From: [REDACTED]
Sent: 29 August 2023 17:48
To: Planning
Subject: FAO: Emily Pickup - Planning Application No: 3/2023/0627

Following [REDACTED] 95 King Street, Whalley, on the 22nd August 2023 I would like to make a few comments / concerns.

Address of Development: 95,King Street, Whalley,BB7 9SW

Drawing file: planx_downloads / 23_0627_Proposed_Plans.pdf

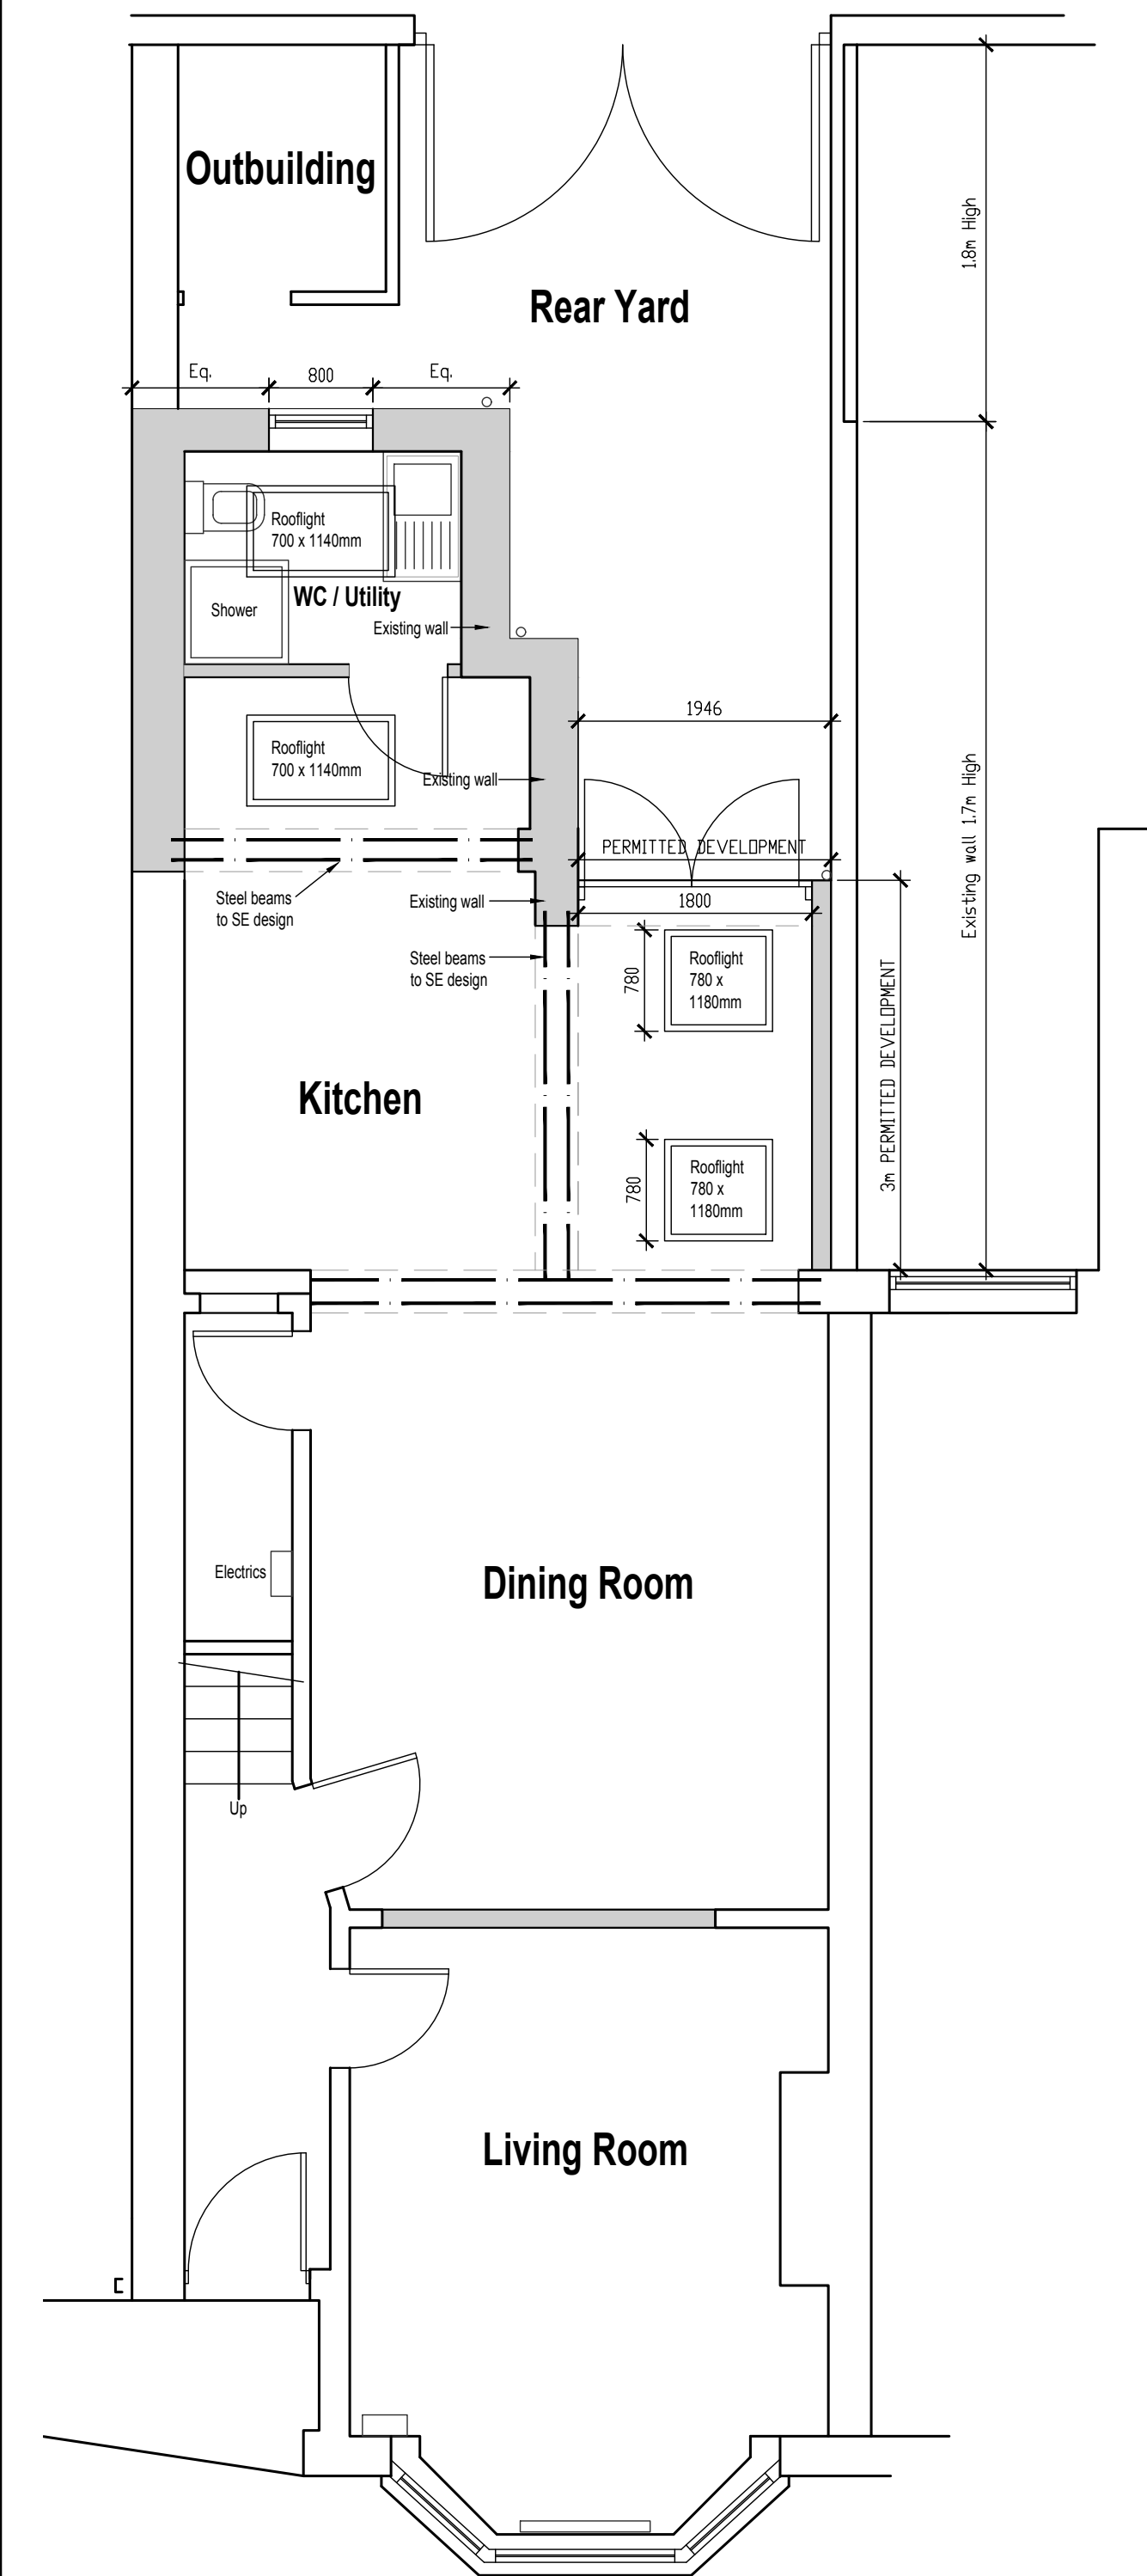
1. The plans are extremely deceptive. The proposed side elevation (North facing) shows the proposed extension roof to meet the existing garden wall which is 1580mm. However, the rear elevation (West facing) shows the proposed extension height of 2400mm. This is not only over 800mm higher than the initial plans which have already been refused by yourselves but will [REDACTED] I can only presume this is an error? Can this be clarified please.

2. I am also concerned about the placement of the new guttering and overflow measures for the kitchen extension. The height of this suggests the guttering will be eye level. Is this correct?

3. The white render is not in keeping with the surrounding houses in this conservation area.
4. The aluminium doors - see above.
5. I have significant concerns about the parking for the property. As it currently stands parking is already an issue as owners / builders of the above named property have blocked the back street for their own parking needs. This is going to become a bigger concern as the 2 bedroom property becomes a 4 bedroom home with no parking facilities. (King Street is 2hrs parking).

6. What materials are being used for the roof?
